Outline application for approval of access arrangements to serve 68 residential units.
Land South of Littlehampton Academy Littlehampton

Thank you for your internet comments made on 7th April 2014 which has been recorded as **'an objection'** with the comments as follows:

The Town Council's Planning and Transportation Committee considered this matter at its meeting held on 31st March 2014 and object to the application on the following grounds:

Client			
West Sussex County Council			
Project			
Land South of Littlehampton Academy			
Drawing Title			
Western Access Arrangement Existing Layout			
Scale	Drawn By	Checked By	Approved By
1:500	PJB	PJC	PMR
Drawing No.	Date	Rev.	
13/1693/003	August 2013	-

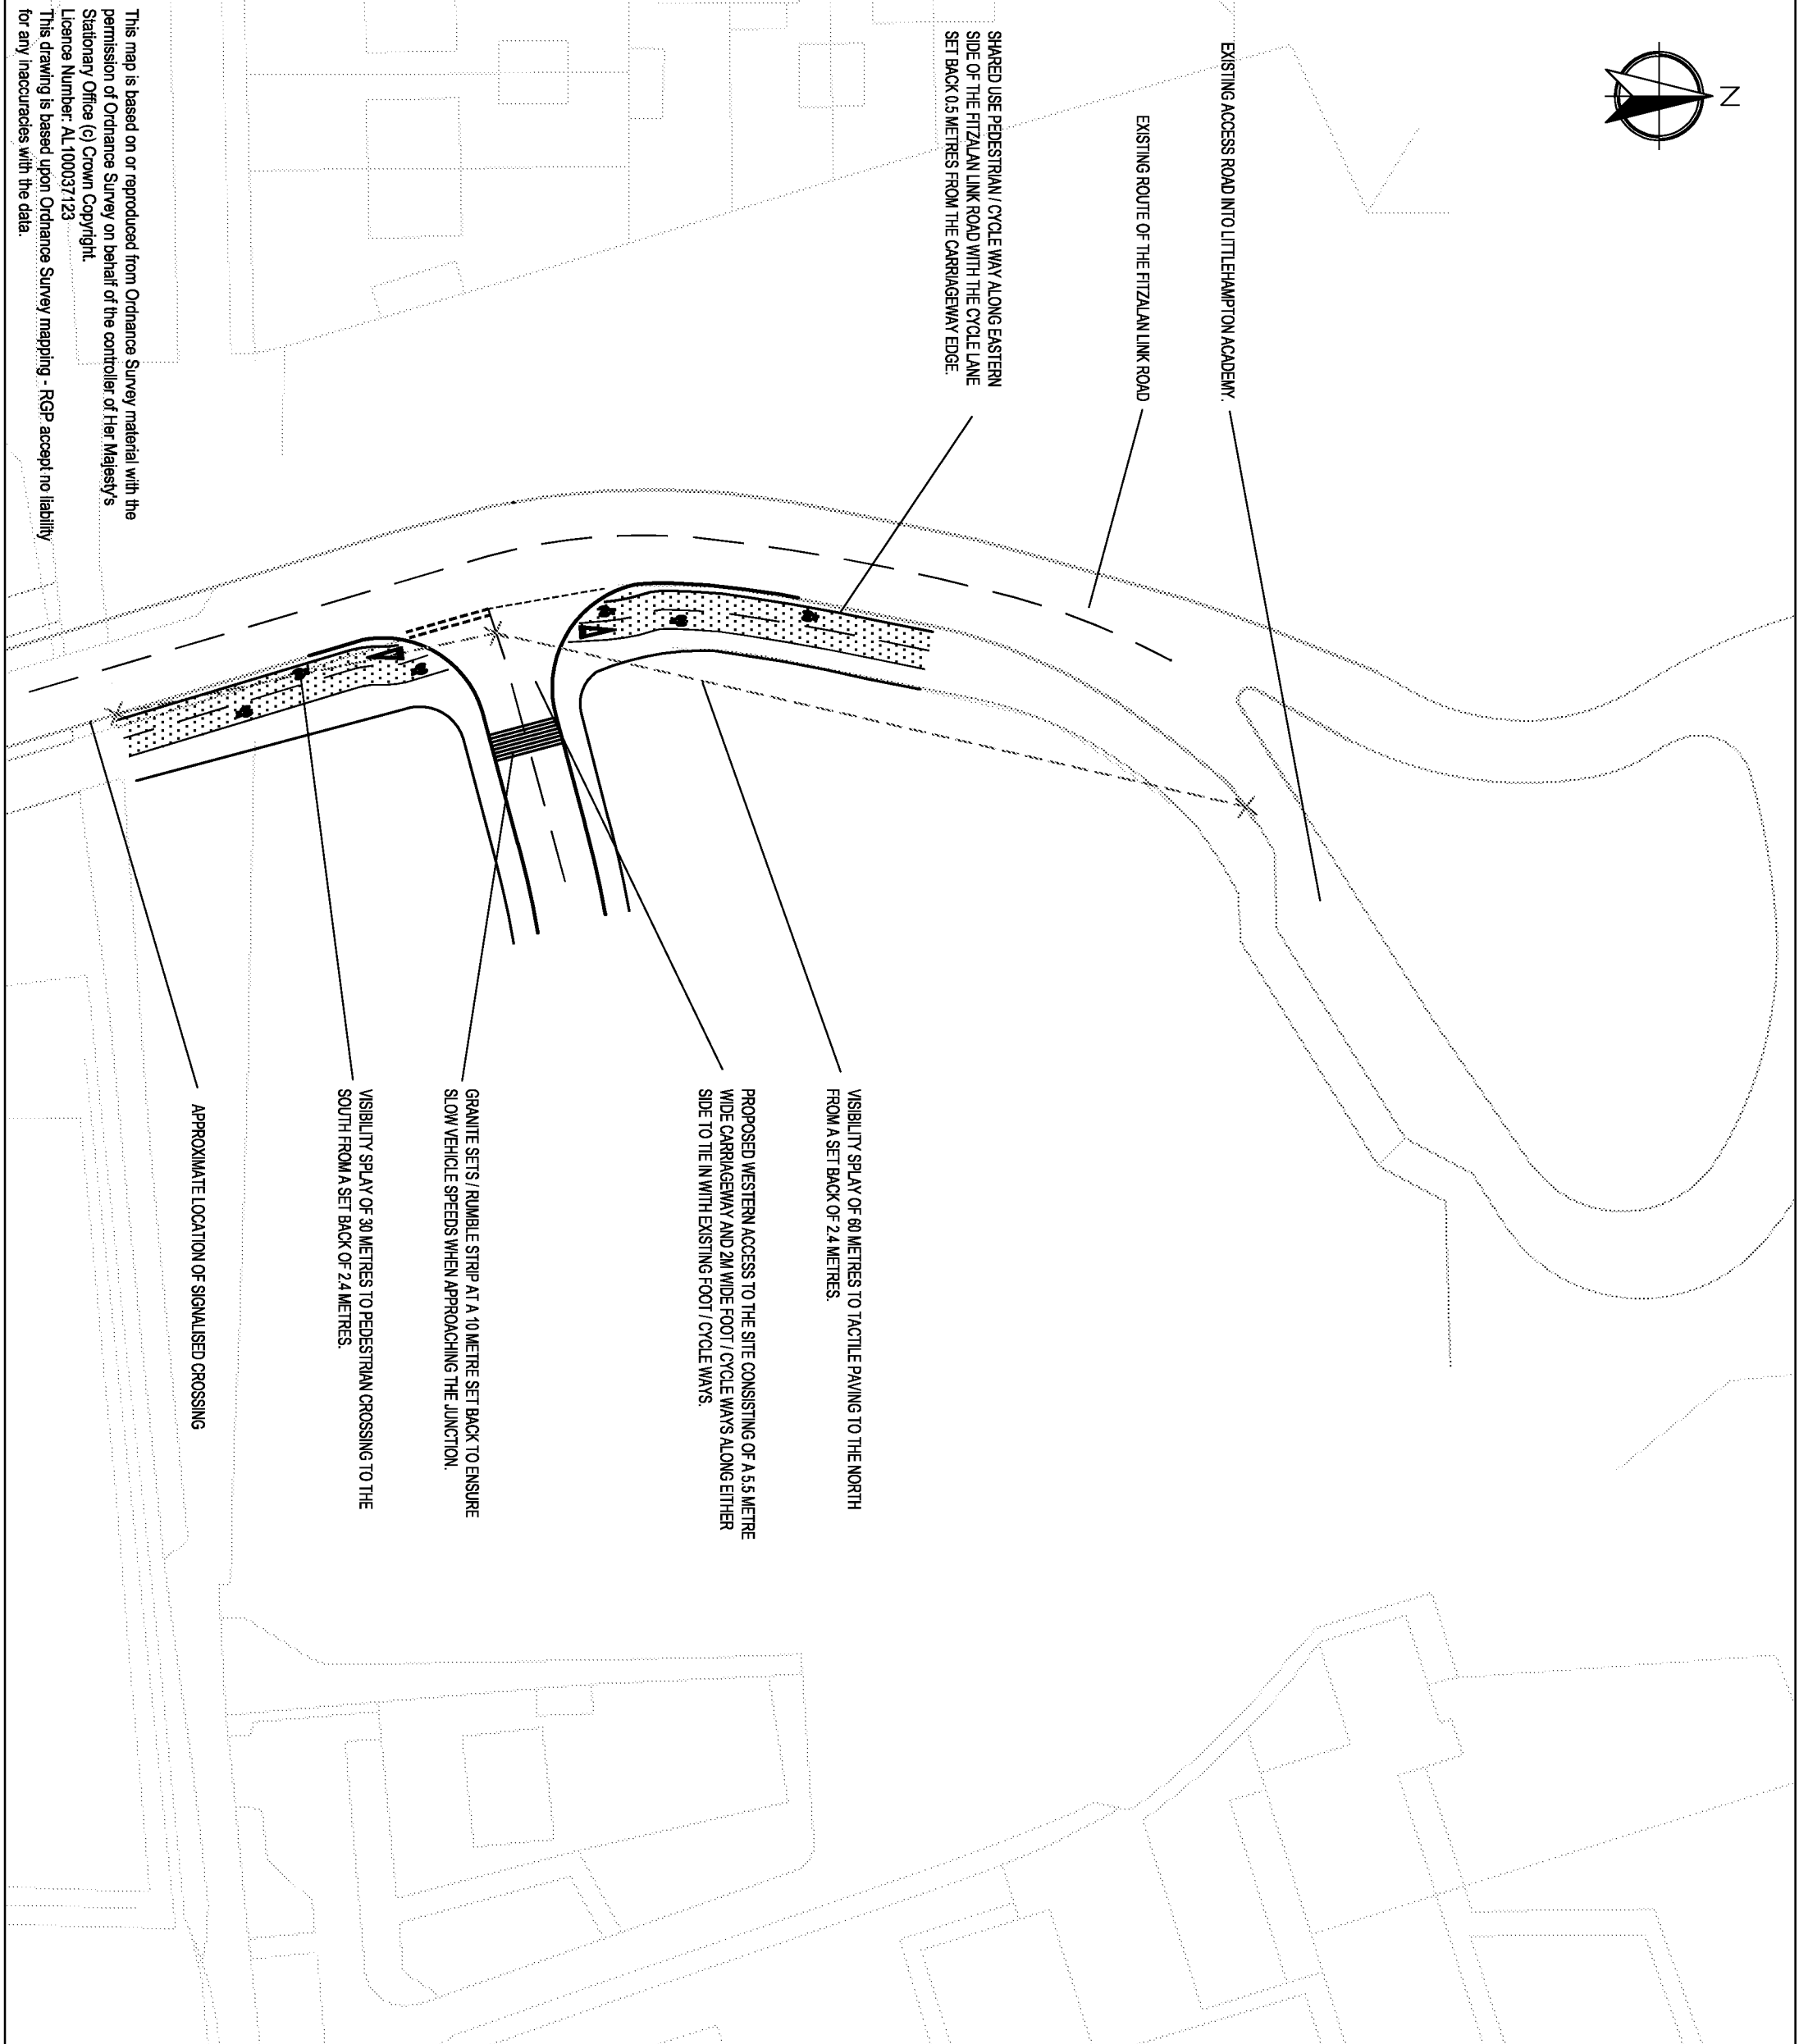
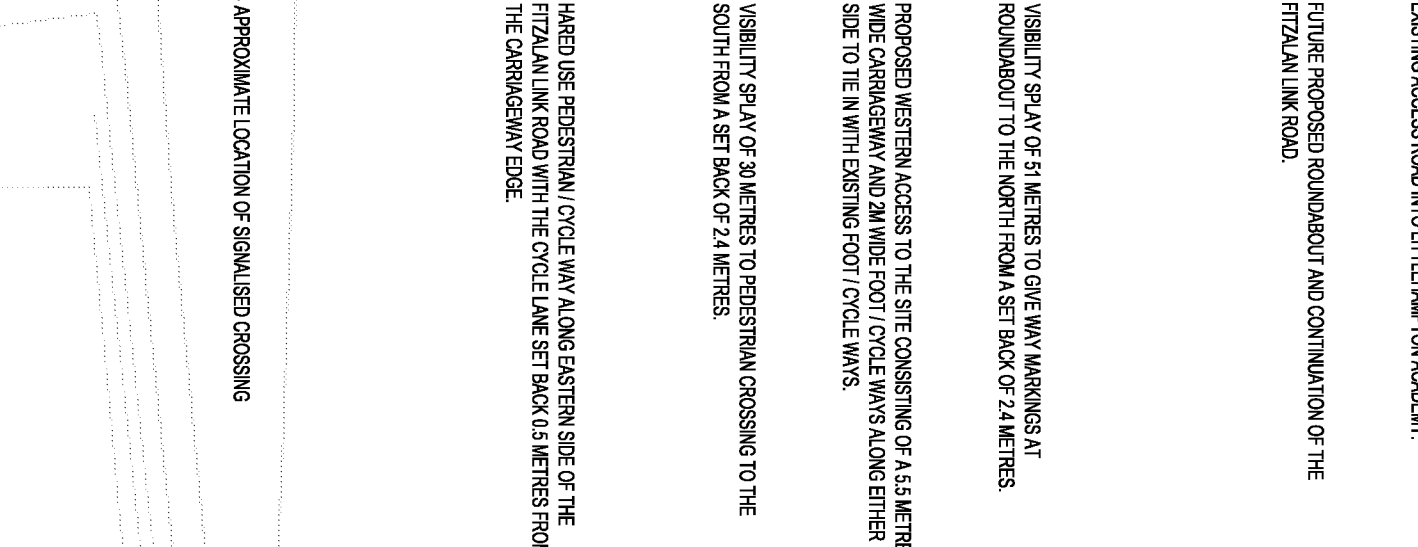
ii. It is proposed that the site is accessed via Elm Grove Road which again is against the Neighbourhood Plan, Policy 4, point 4.3.11, which states that if developed, this site should be accessed from the new Fitzalan Link road to the west and not Elm Grove Road. The

iii. In addition the Town Council considers that access to the site would be safer if facilitated at the Fitzalan Link road by way of a filter lane as opposed to the proposed roundabout and that the road widths need to be of sufficient width to accommodate domestic and amenity vehicles.
